Final Drainage Report The Rock Commerce Center

PCD File No. PPR2329

July 28, 2023
October 20, 2023
Project No. 23009.001

PROPOSED BUILDING
163,800 S.F.
THE ROCK COMMERCE CENTER
19165 MONUMENT HILL ROAD

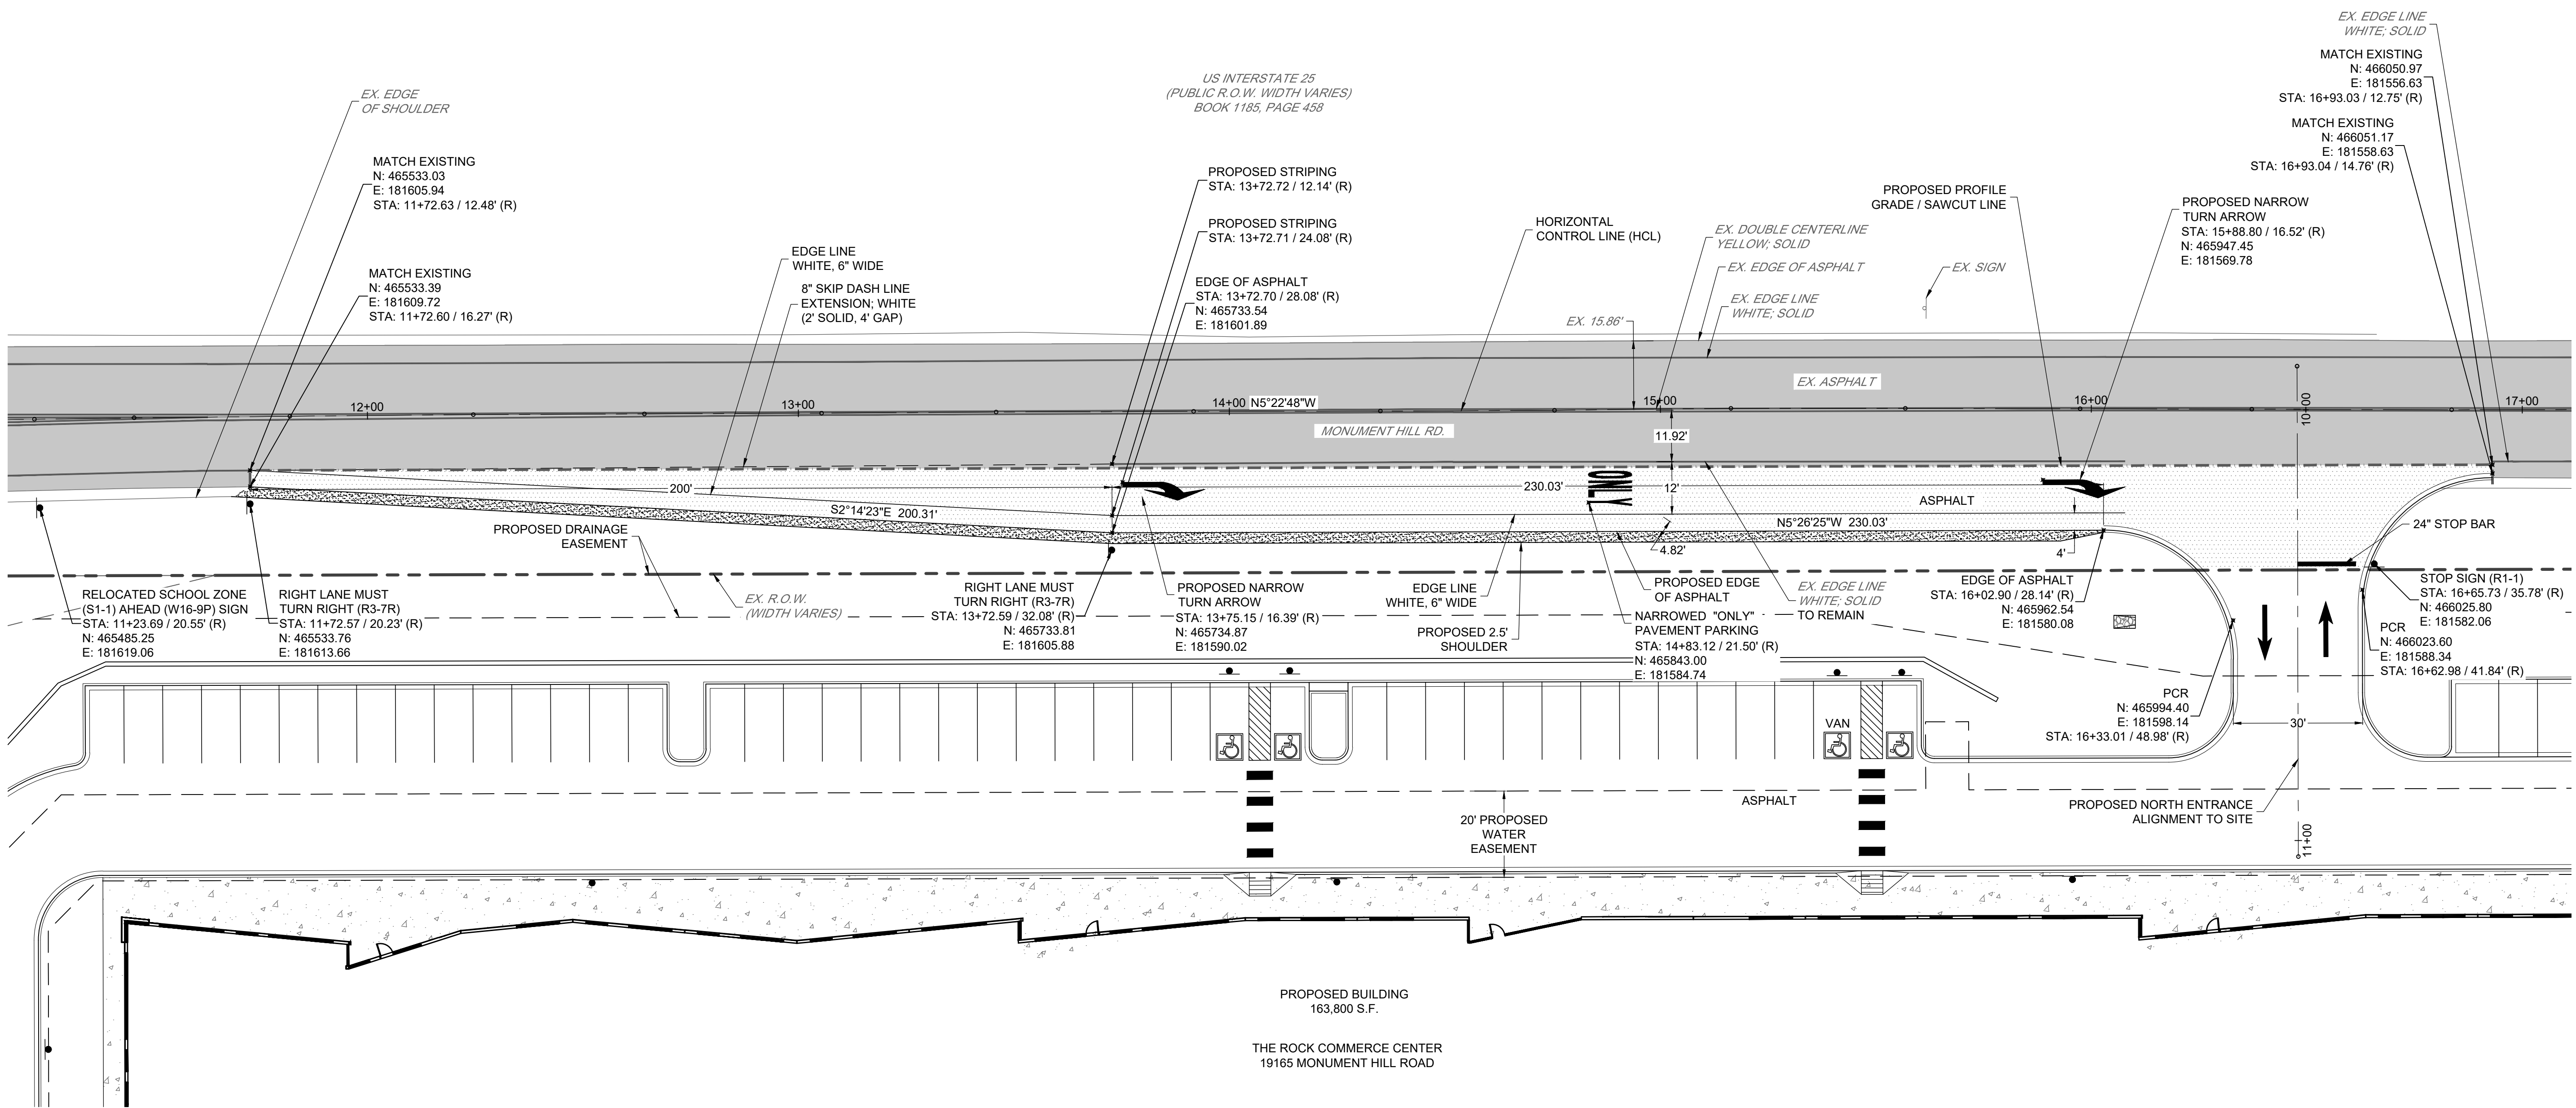
Unresolved:
LOI and TIS state 163,800 sf please revise for consistency.
